FINAL SITE/SUBDIVISION PLAN OF 23 OCEAN AVENUE, PORTLAND, MAINE
FOR RECORDED OWNERS: STEVEN E. AND ROBERTA S. COPE
PORTLAND, MAINE 04104

1/22 PLANNING

FINAL SITE/SUBDIVISION PLAN
 OF: 23 OCEAN AVENUE
 PORTLAND, MAINE
 FOR RECORD OWNER:
 23 OCEAN AVENUE ASSOCIATES, LLC
 P.O. BOX 1398
 PORTLAND, MAINE 04104
 PLAN DATE: 06/04/2016

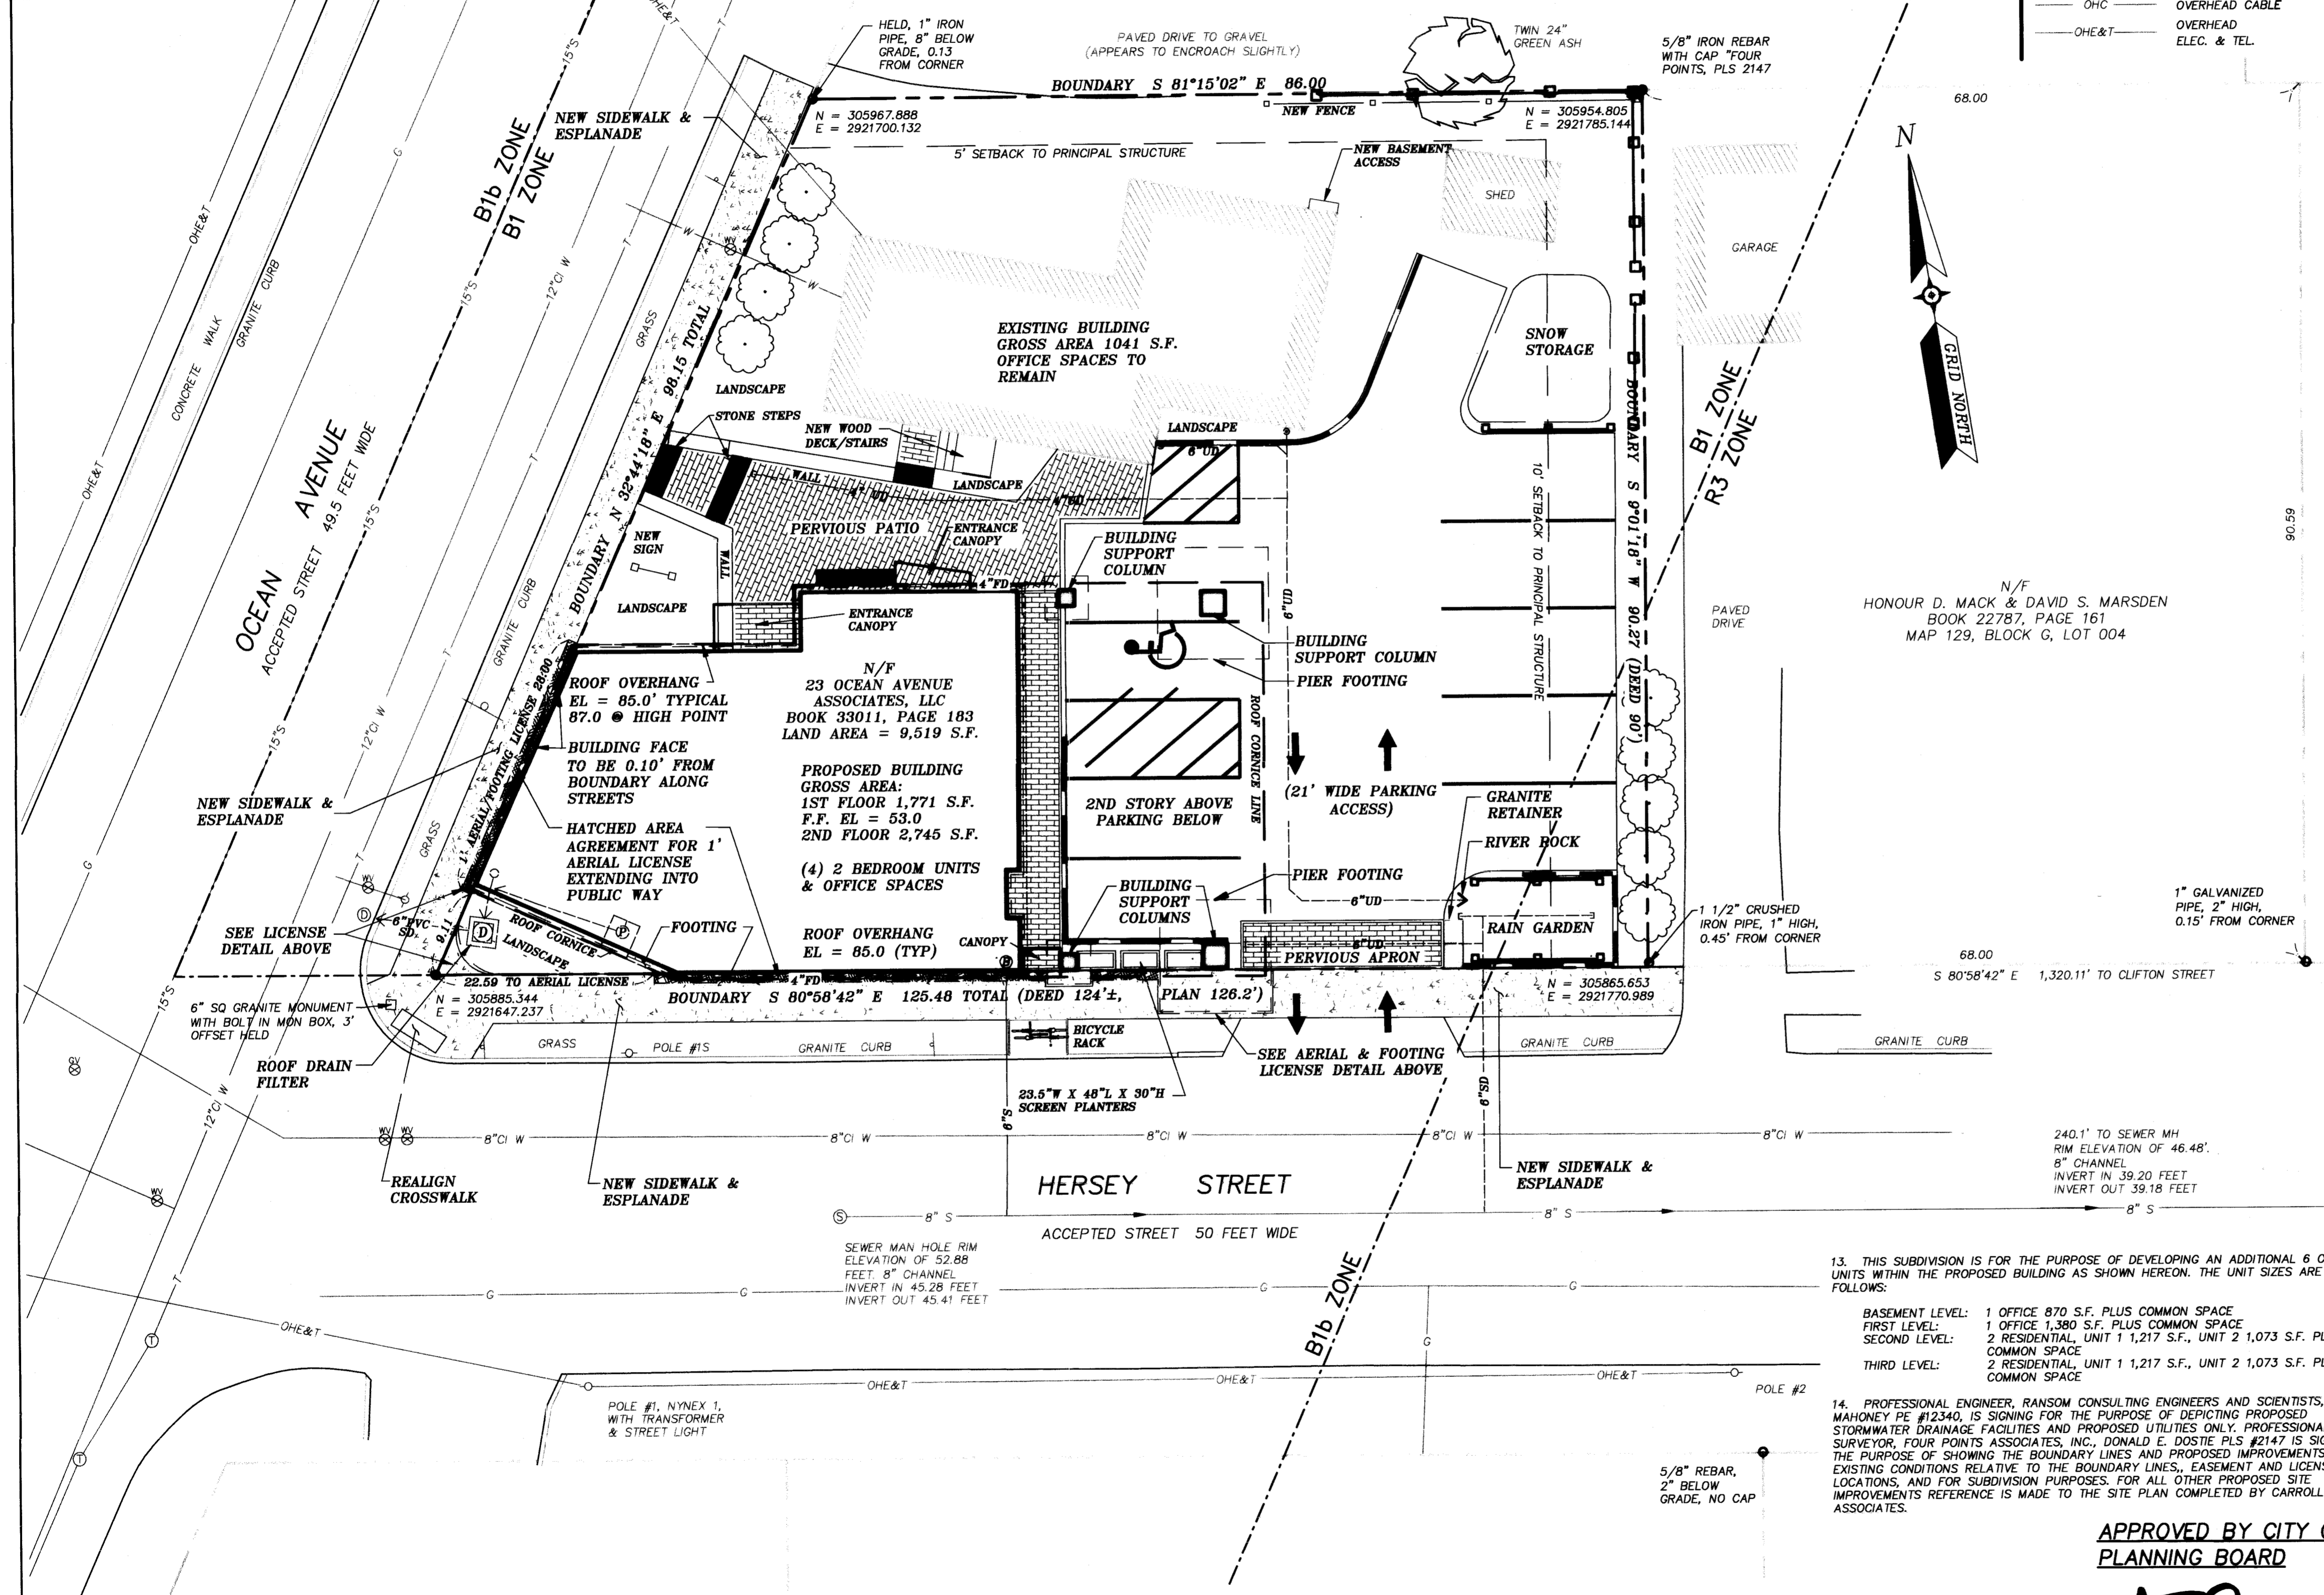
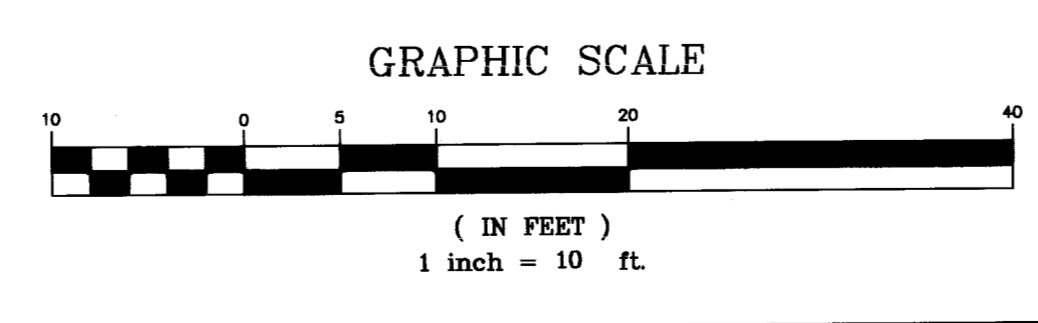
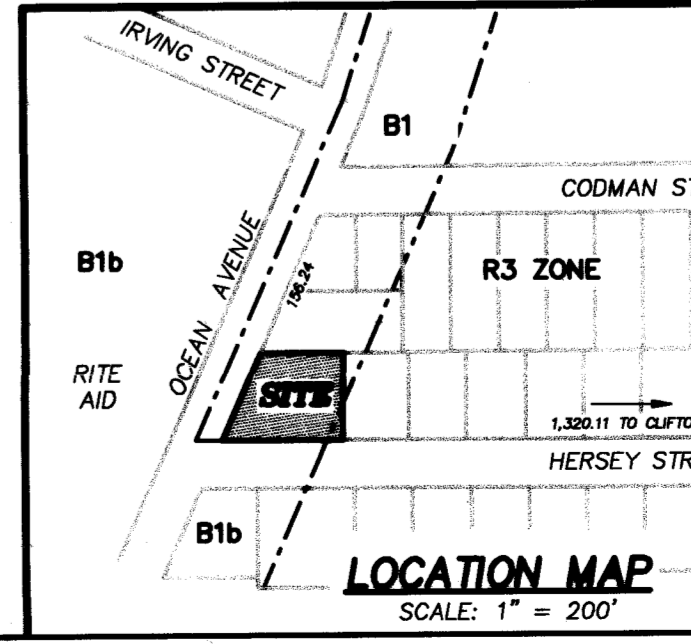
* ADD NOTES DESCRIBING RES + COMMERCIAL/OFFICE SUBDIVISION (I.E., USES, # UNITS + UNIT SIZES)

* ADD NOTES RE PROPOSED a) LICENSE(S) b) EASEMENT w/ SPACE FOR BOOK PAGE

* ADD WAIVER NOTE (QUOTING WAIVER)

REFERENCE BOOK + PAGE + SHOW LOCATION OF STORMWATER INFRASTRUCTURE ON PLAT.
